## Application by Springwell Energy Farm Limited for an Order Granting Development Consent for the Springwell Solar Farm

### The Examining Authority's written questions and requests for information (ExQ1)

**Issued on 13 May 2025**

TITLE:
FIGURE 3.3B
GREEN INFRASTRUCTURE PARAMETERS
SPRINGWELL EAST

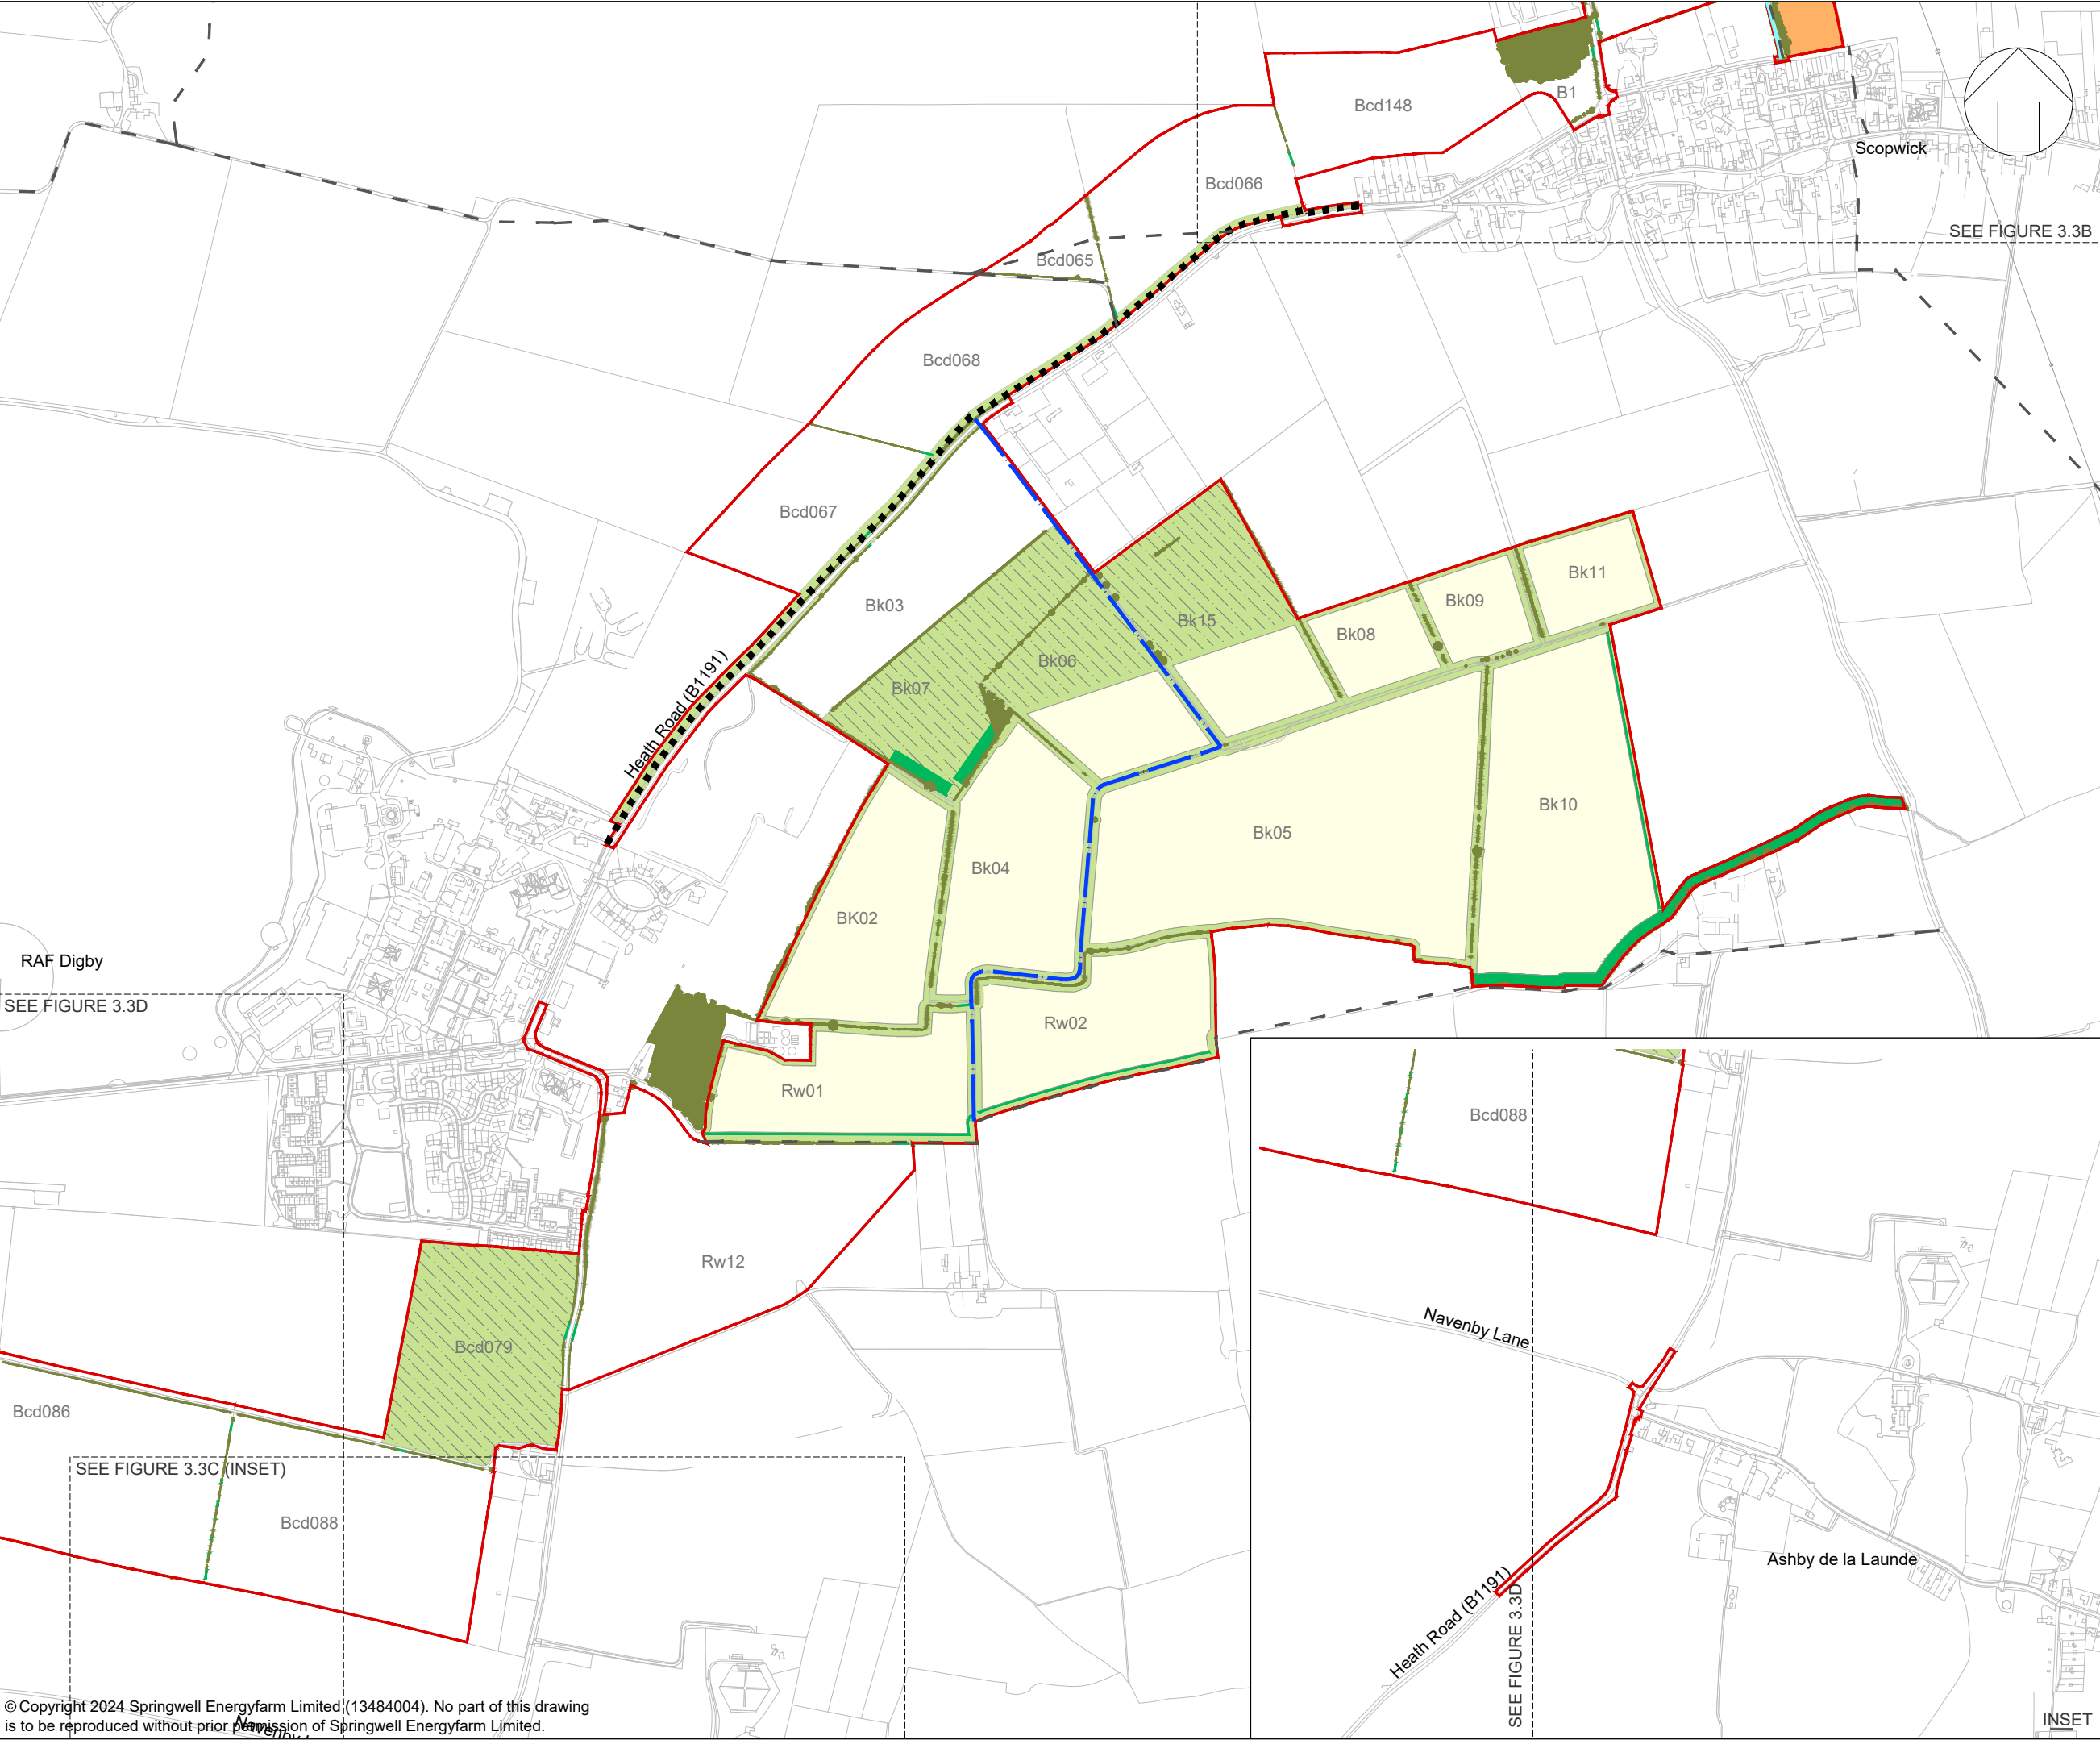
Q1.4.12	Applicant	<p><b>Birdstrike</b></p> <p>The Ministry of Defence (MOD) [RR-278] raised concern that the proposed attenuation pond shown in field Tb2 on the Illustrative Layout Plans [AS-006] has the potential to attract and support bird species hazardous to air traffic. It considers a requirement necessary to ensure that proposed waterbodies or wetland features would not introduce a birdstrike hazard to aircraft.</p> <p>c. Provide further information on the proposed attenuation pond and whether it has been designed and managed to support bird species.</p> <p>d. Provide comment on the MOD's proposed requirement.</p>
<b>5. Climate Change</b>
